OFFICIAL NOTIFICATION OF DECISION

FILE: **Project # 1002176**
 04EPC-00161 EPC Site Development Plan-
 Building Permit
 04EPC-00162 EPC Site Development Plan-
 Subdivision
 04EPC-00163 Zone Map Amendment

LEGAL DESCRIPTION: for all or a portion of Tracts E-1, **North Four Hills**, zoned C-1 to SU-1 Single Family Residential, located on SE QUAD OF FOUR HILLS ROAD SE, between CENTRAL AVE. SE and WATERFALL Drive SE, containing approximately 7 acres. (L-23)
 Deborah Stover, Staff Planner

TYPICAL LANDSCAPE LOT LAYOUT
 NTS

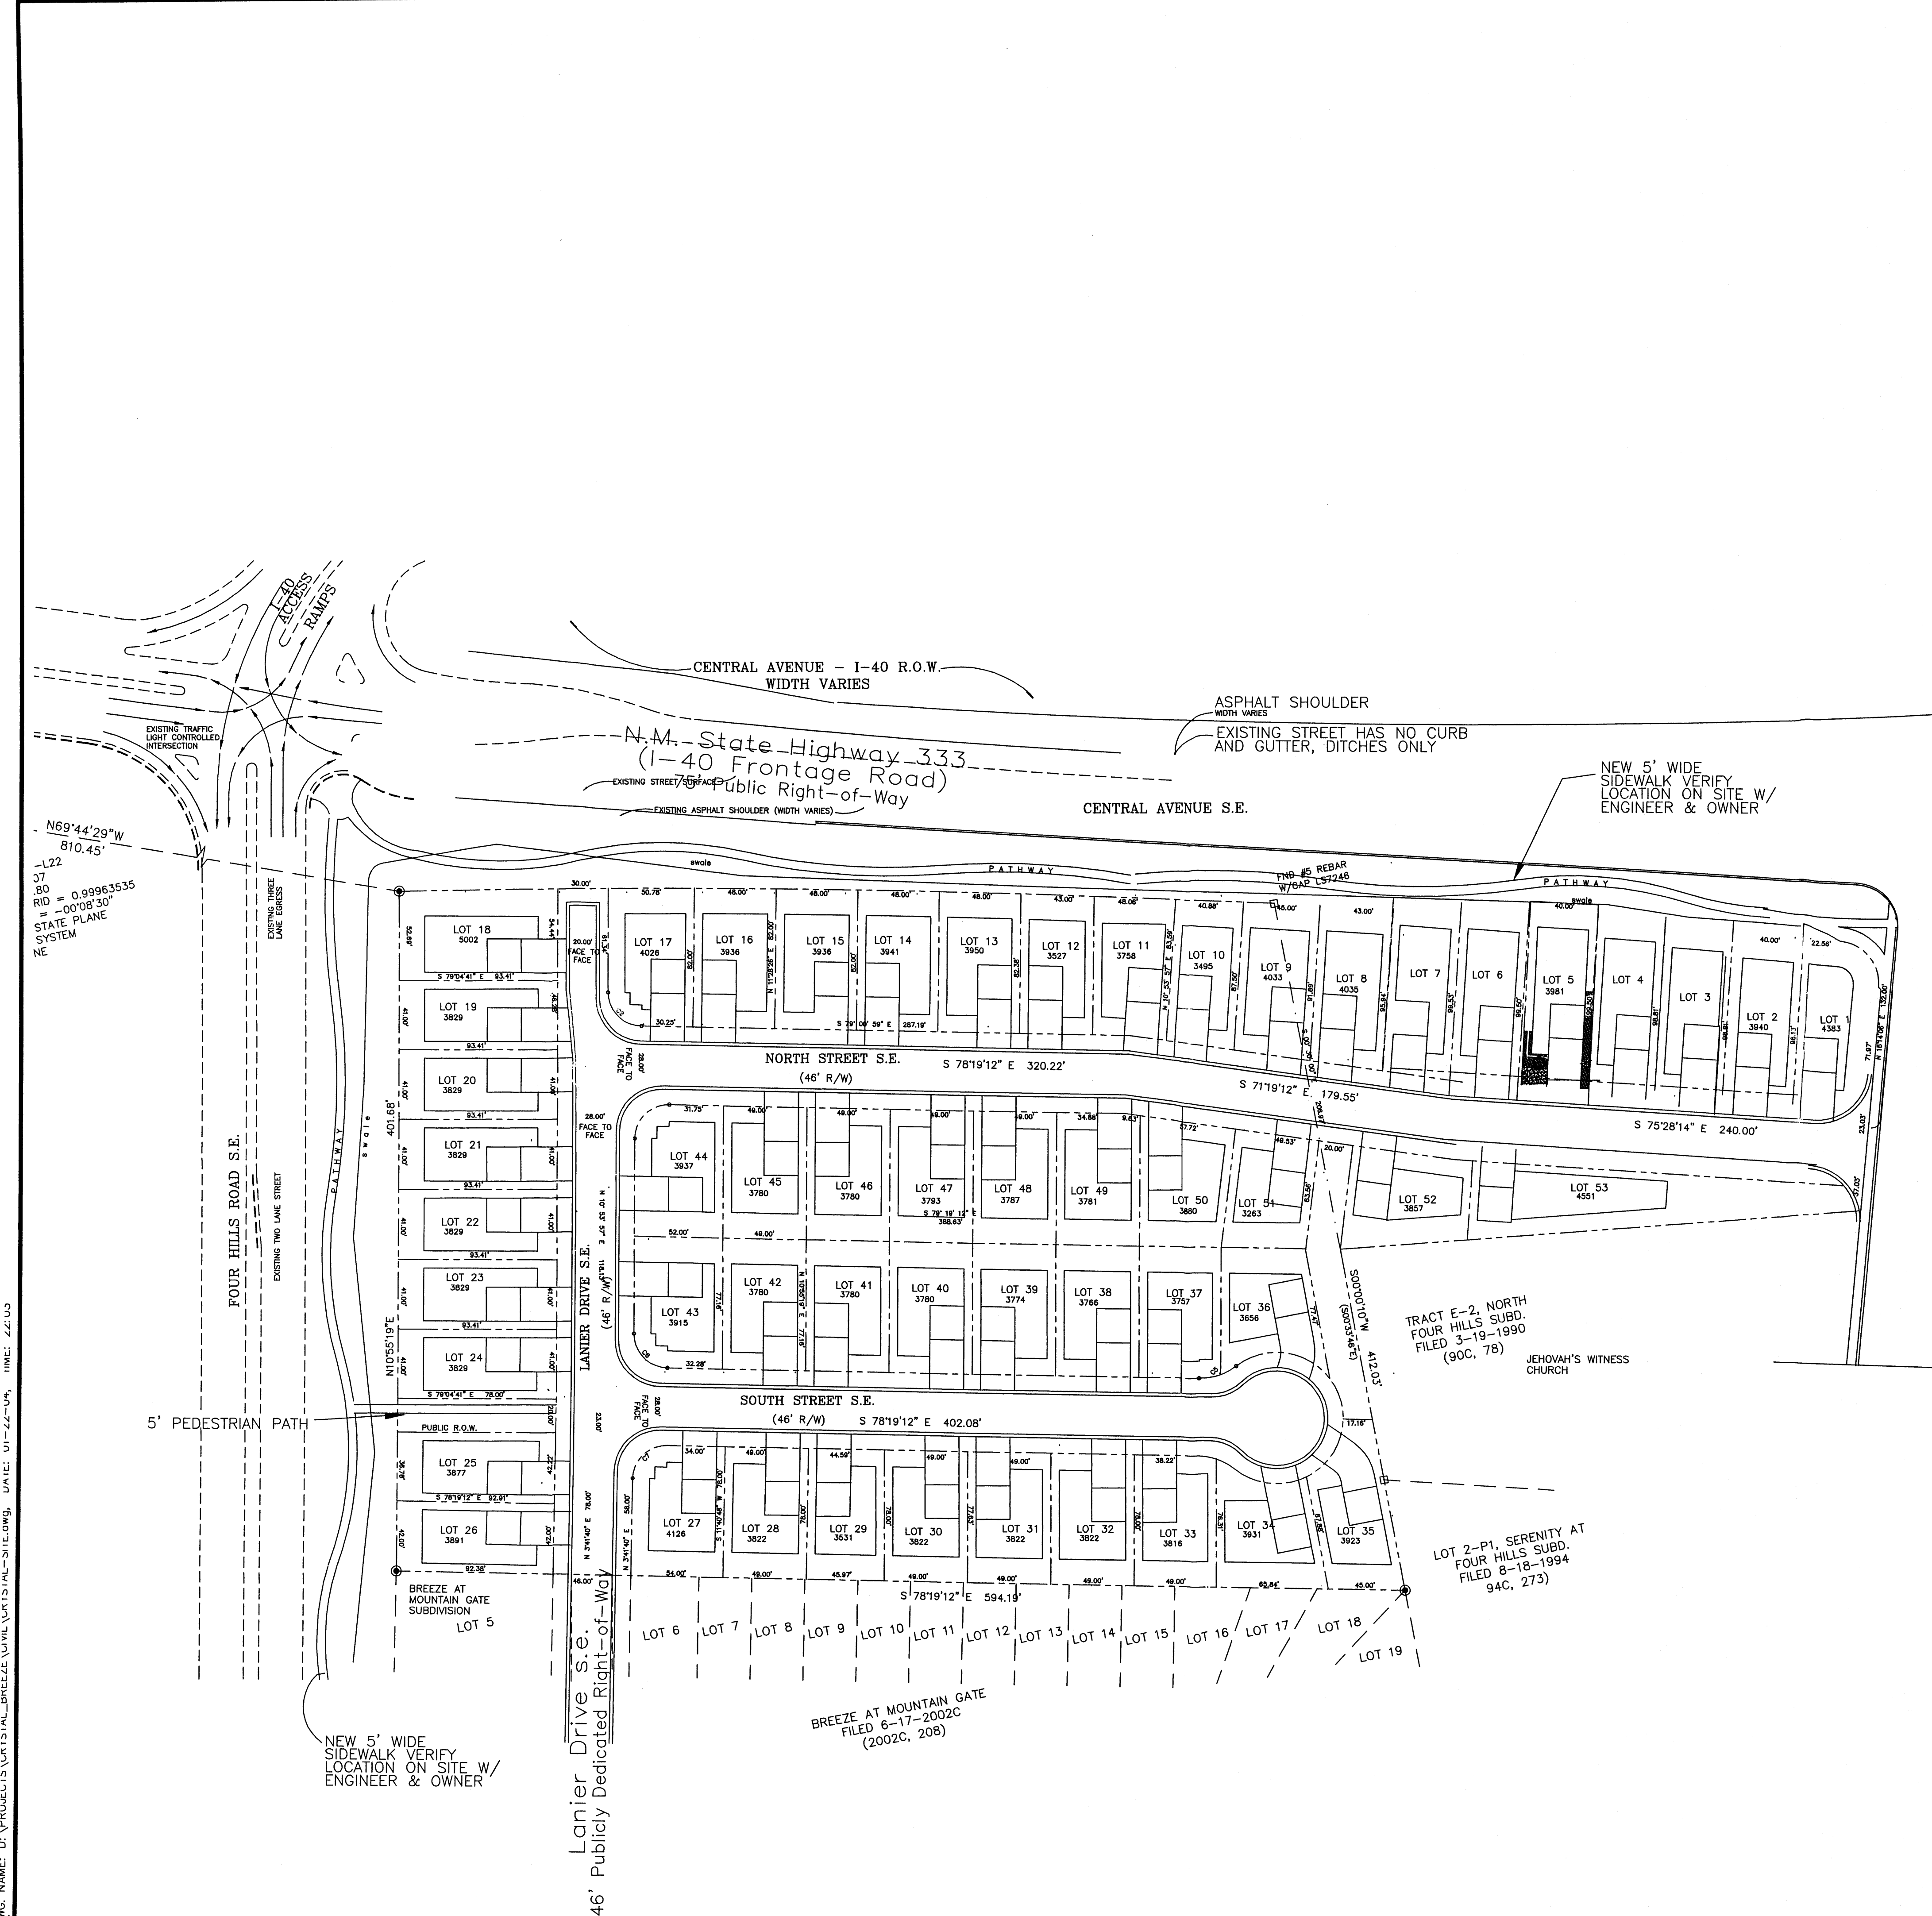
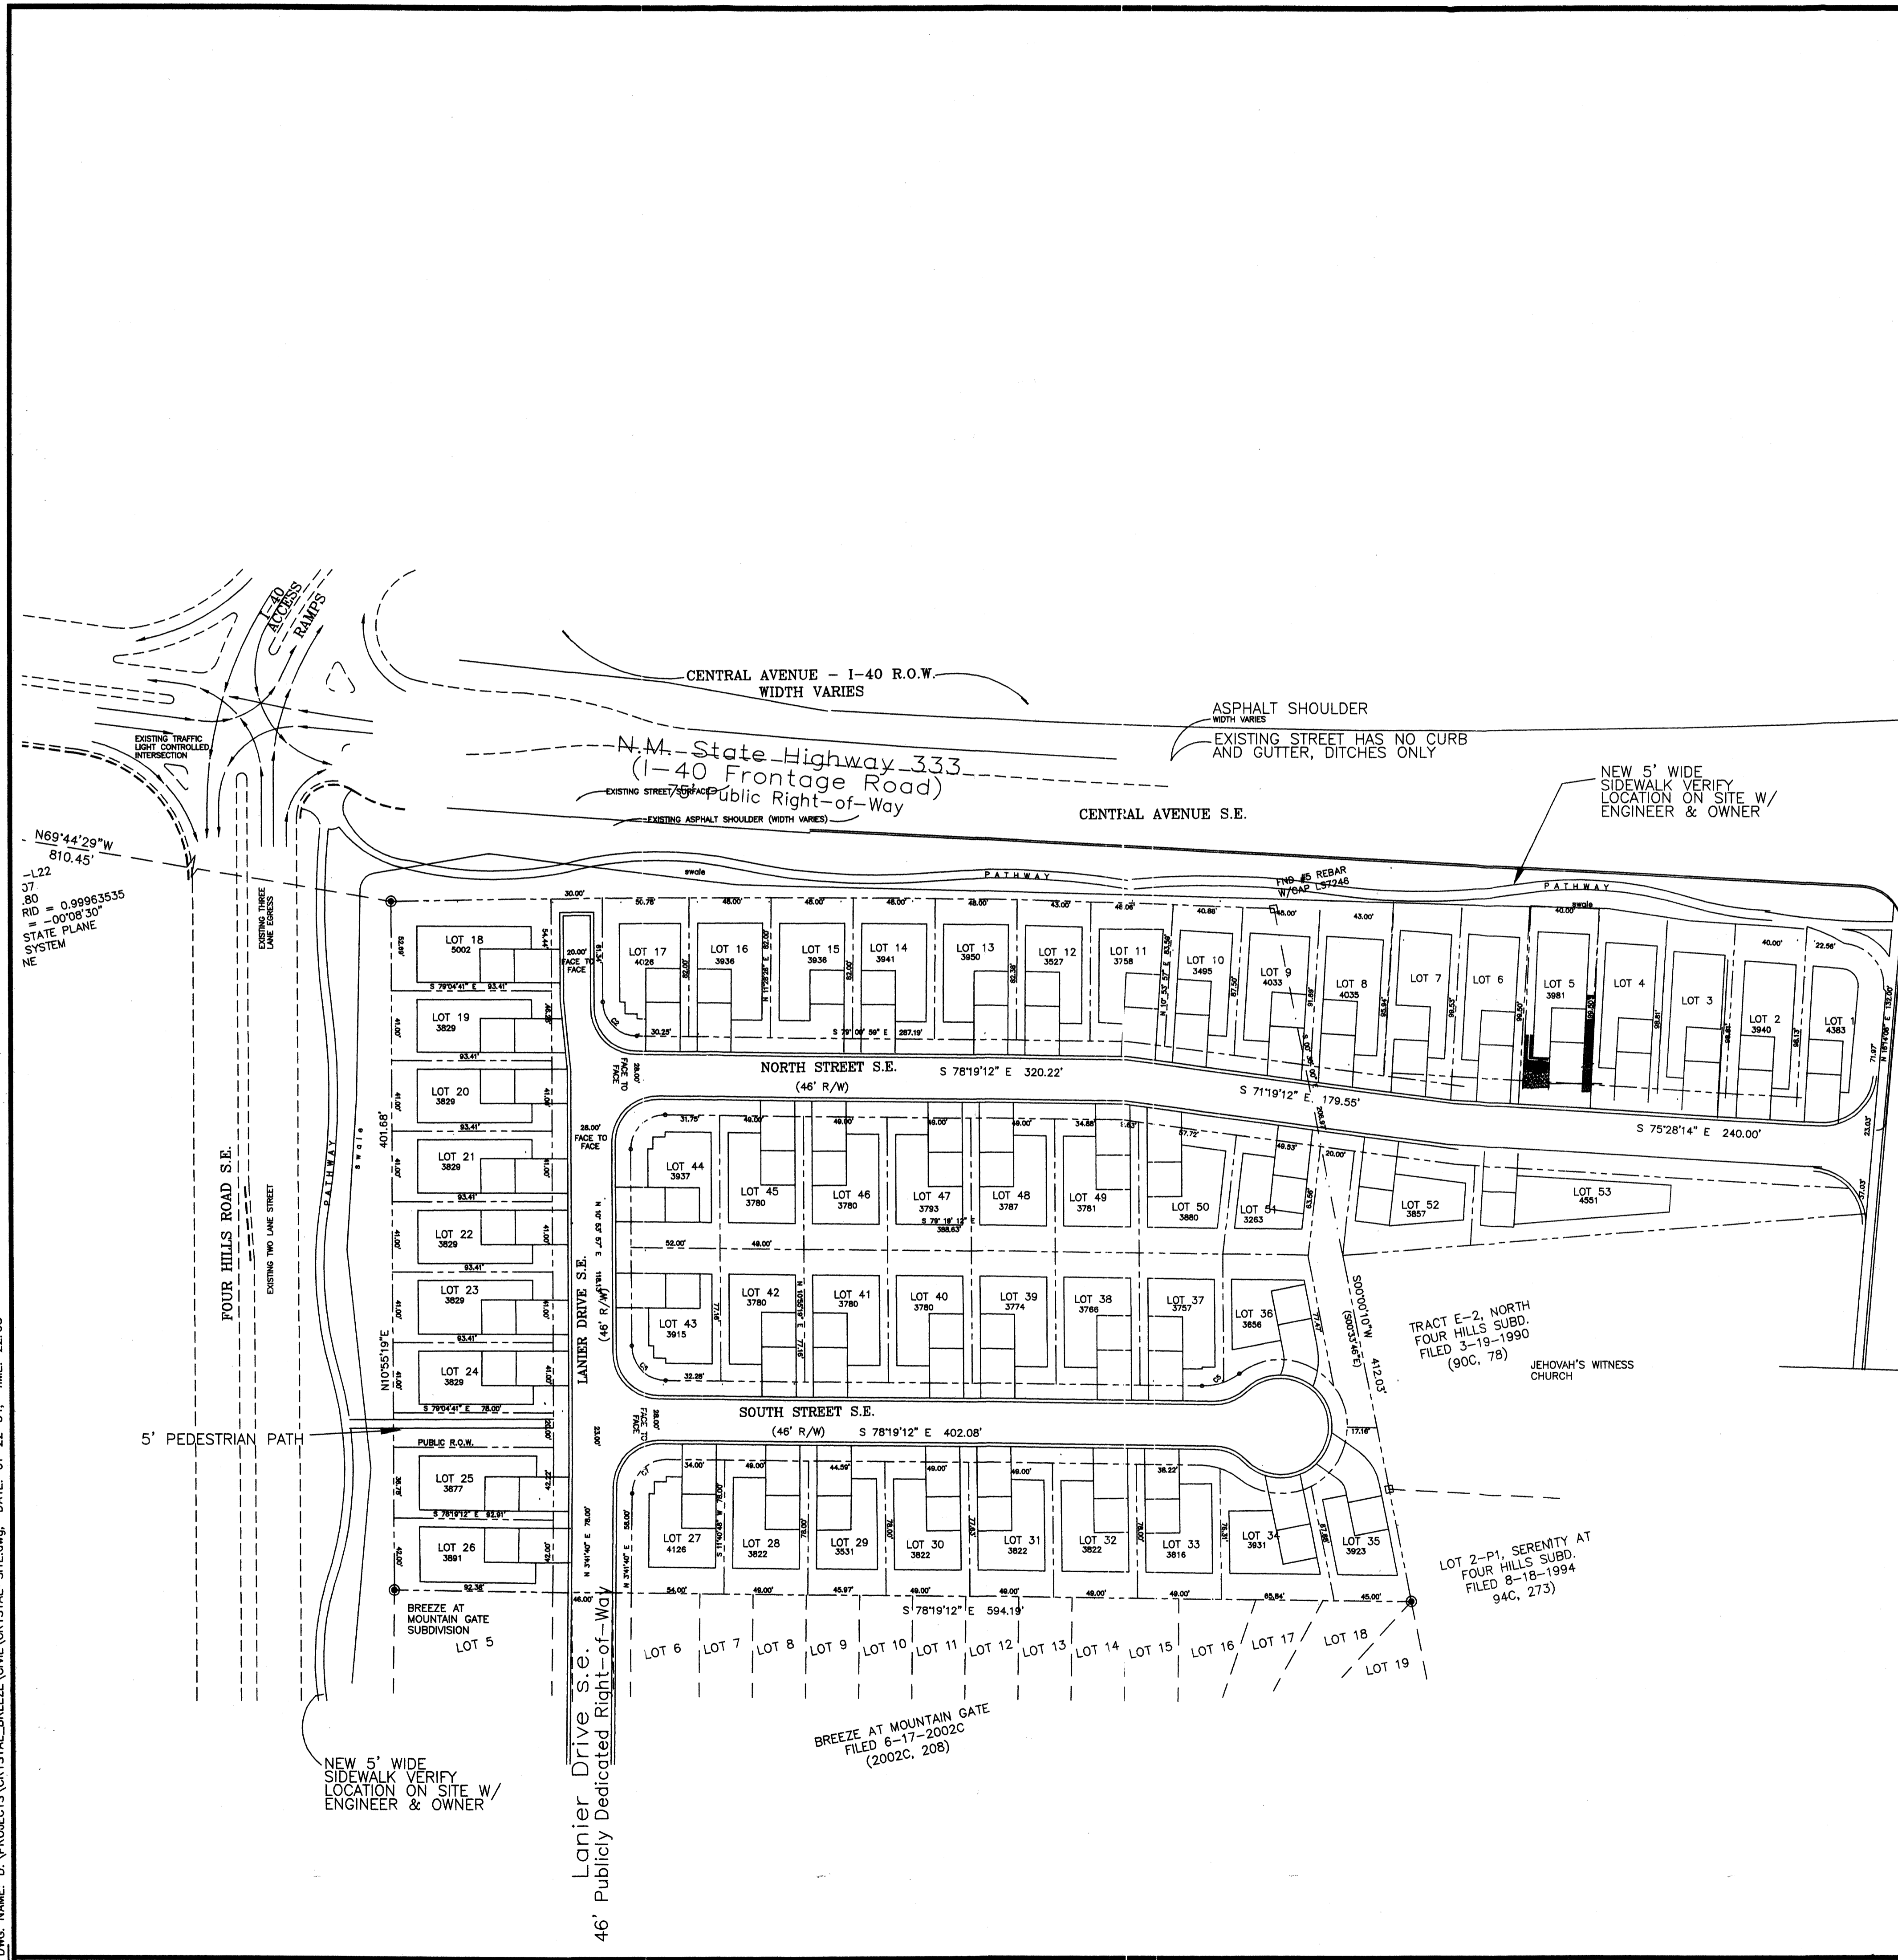
5. The trees and shrubs shall be removed from the general landscape plan. The typical lot landscape is sufficient to show what is intended.
6. The shrubs shown along the pathways parallel to Fours Hills Road and Central Avenue that are not on the subject property shall be removed unless a homeowner's association is planned to provide maintenance for these plants.

7. The gravel for backyards shown on the typical lot landscape shall be removed to allow each homeowner to create their own preferred backyard landscape.

8. The scale on the landscape plan shall be shown as 1"=50' and shall be consistent on the landscape sheet.
9. Garage setbacks shall be varied by at least five-feet every third house.
